Our Ref: A/42/18/HH

**Town & Country Planning Act 1990 (as amended)
Town & country Planning (Development Management Procedure) (England) Order 2015
Application for Planning Permission for Works or Extension to a Dwelling**

Development Demolition of existing conservatory, garage & canopy structure & erection of single storey rear extension
Location 59 Palmer Road Angmering

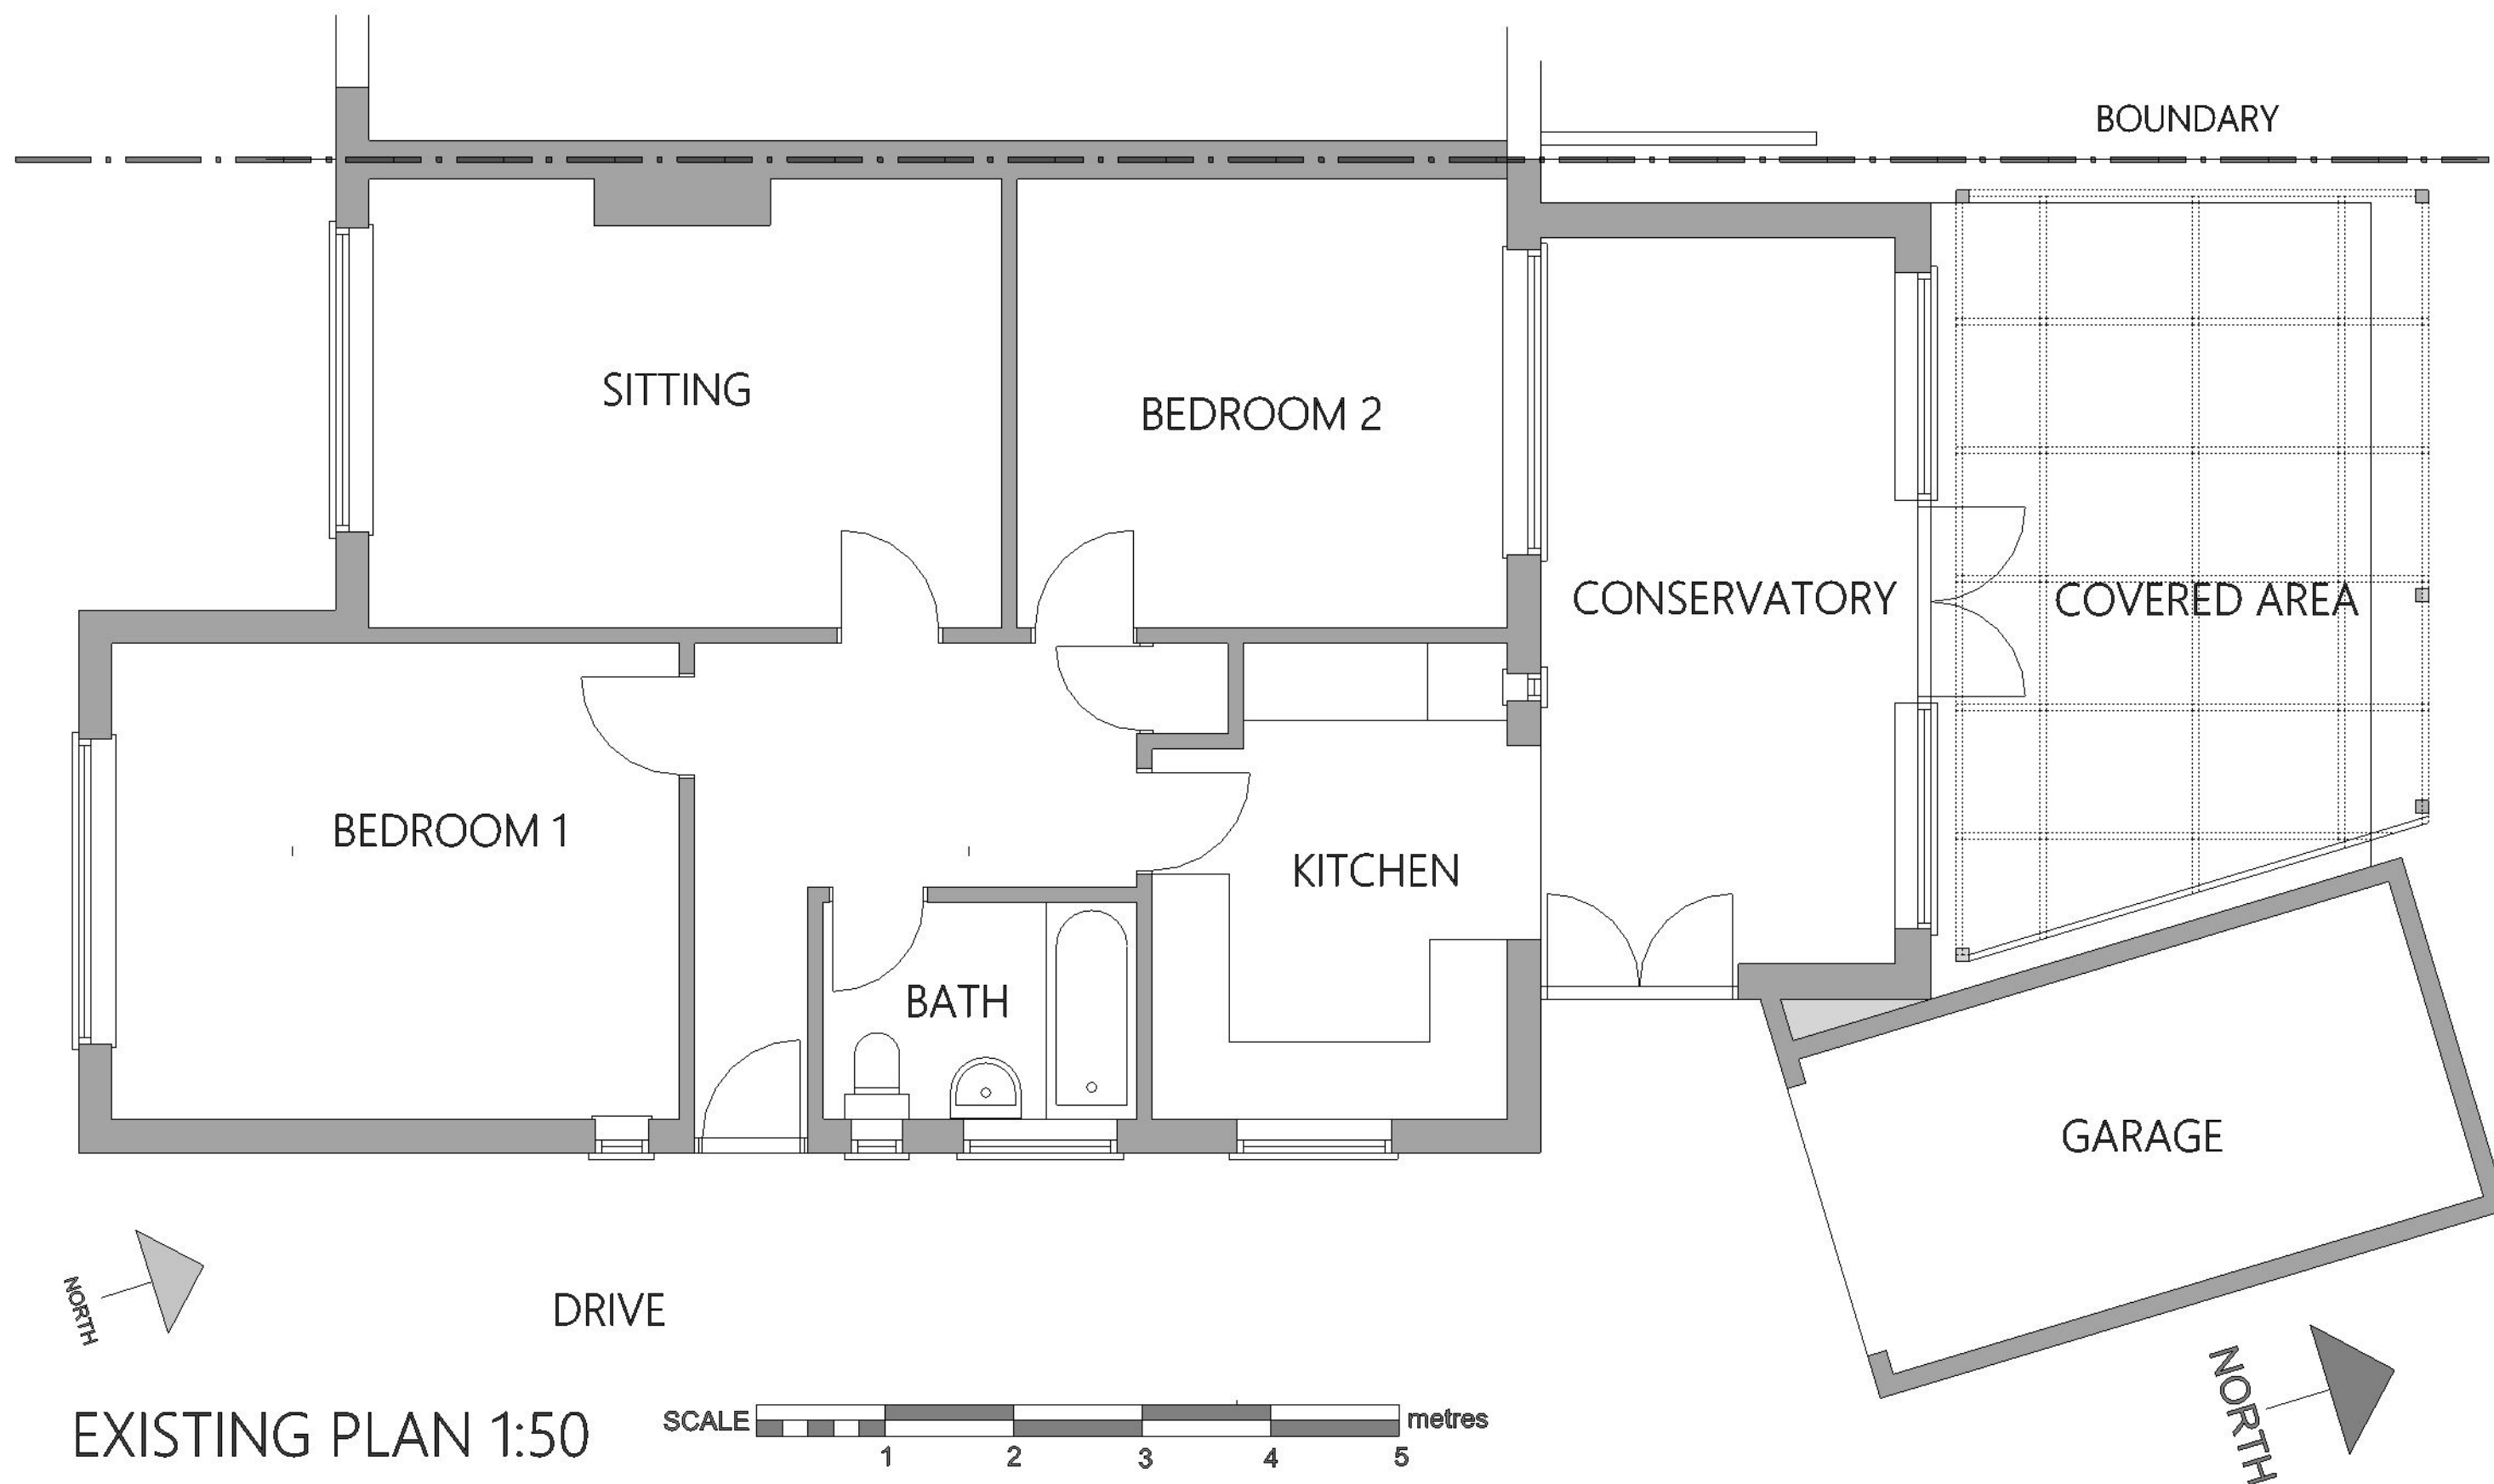
The existing floor plans and elevations do not scale correctly. Please amend accordingly.

PETER ROBSON ARCHITECT	Long Meadow, The Lane, Chichester, PO19 5PY	Drawing: 1604-01 A
	Tel: 01243 780224 Mob: 07497 006277	Revision:
	Email: robsonarchitect@gmail.com	A - Show full proposed site plan and dimensions from boundary 11-4-2018

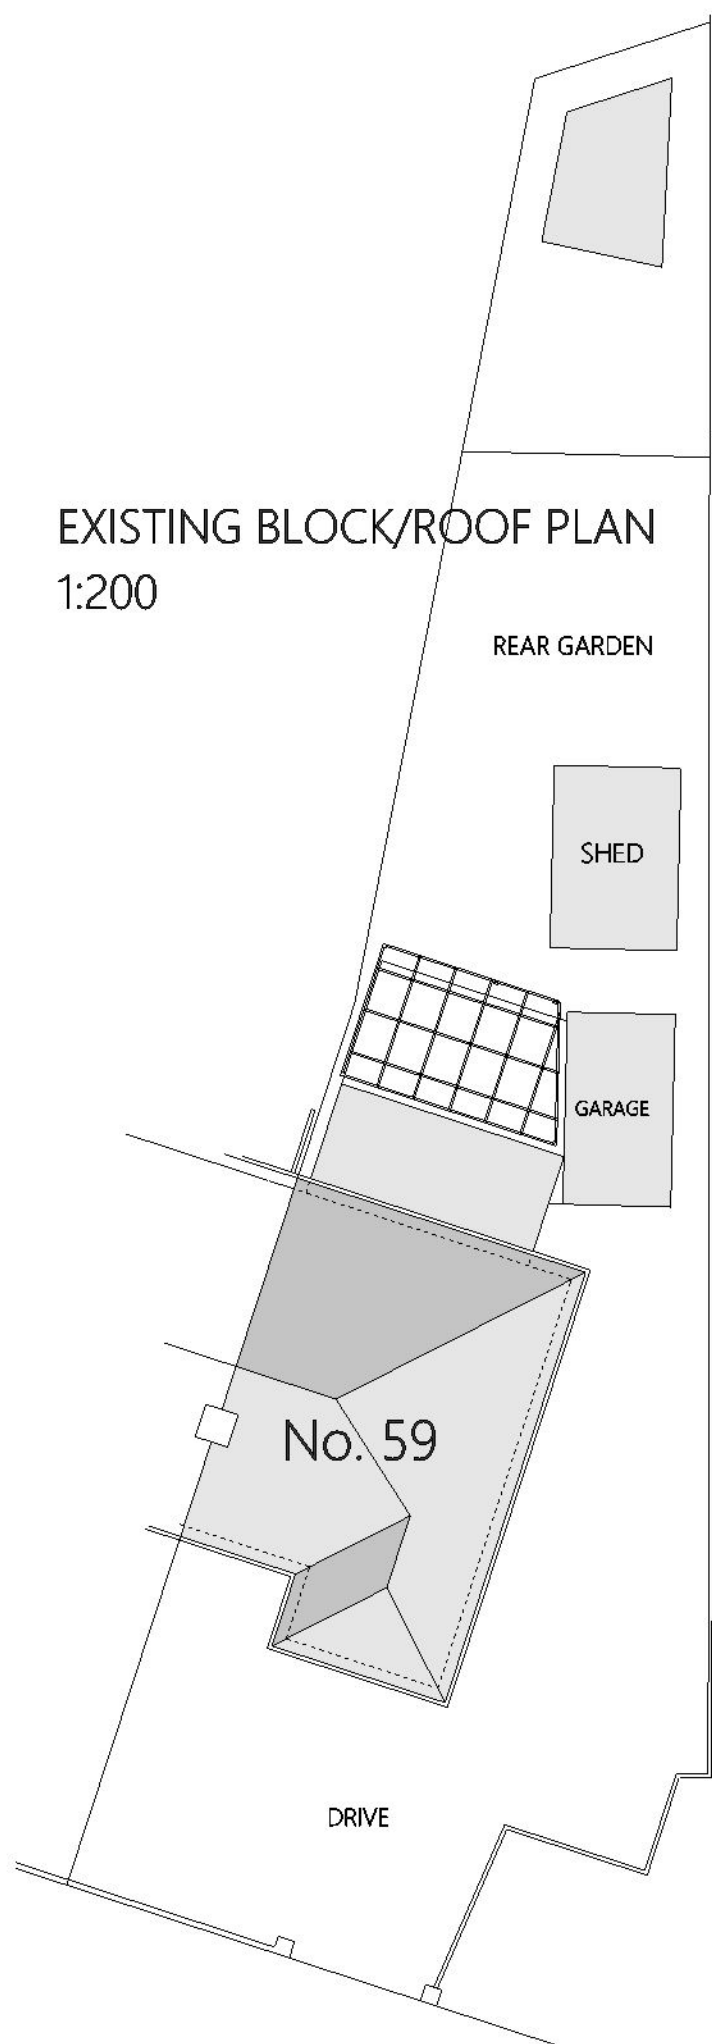
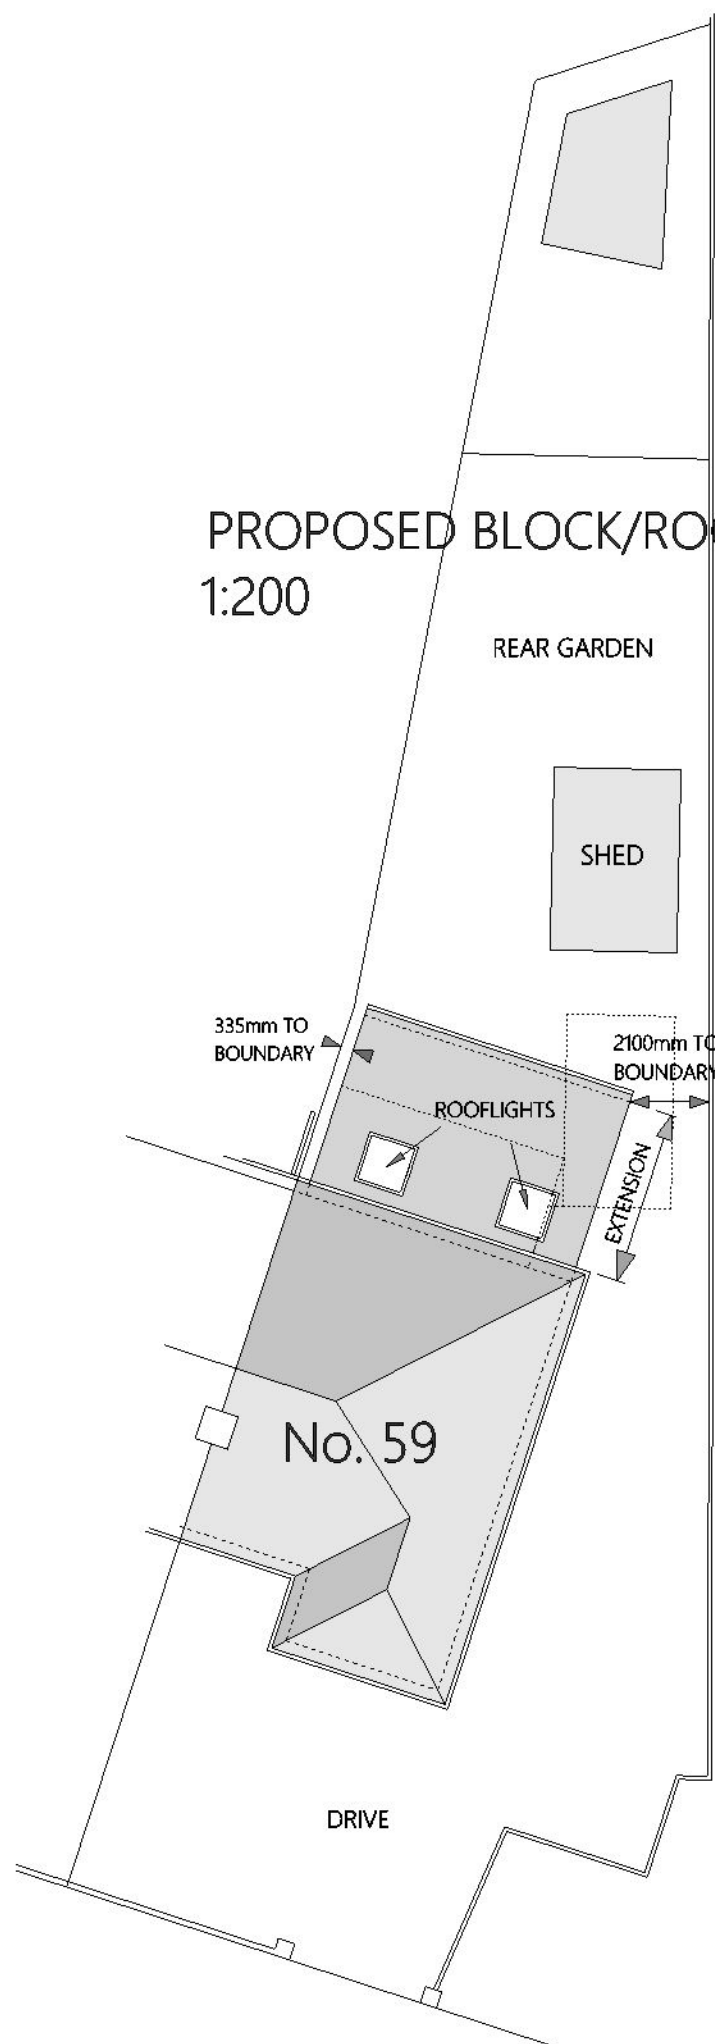
Block Plan Amend

Please submit 1 electronic or 3 paper copies of a block/site plan at a scale of 1:500 or 1:200. Further details of what must be included on the plan can be found in the National Validation Requirements. Please provide a full proposed block plan showing the entire site and provide measurements from the proposal to the site boundaries.
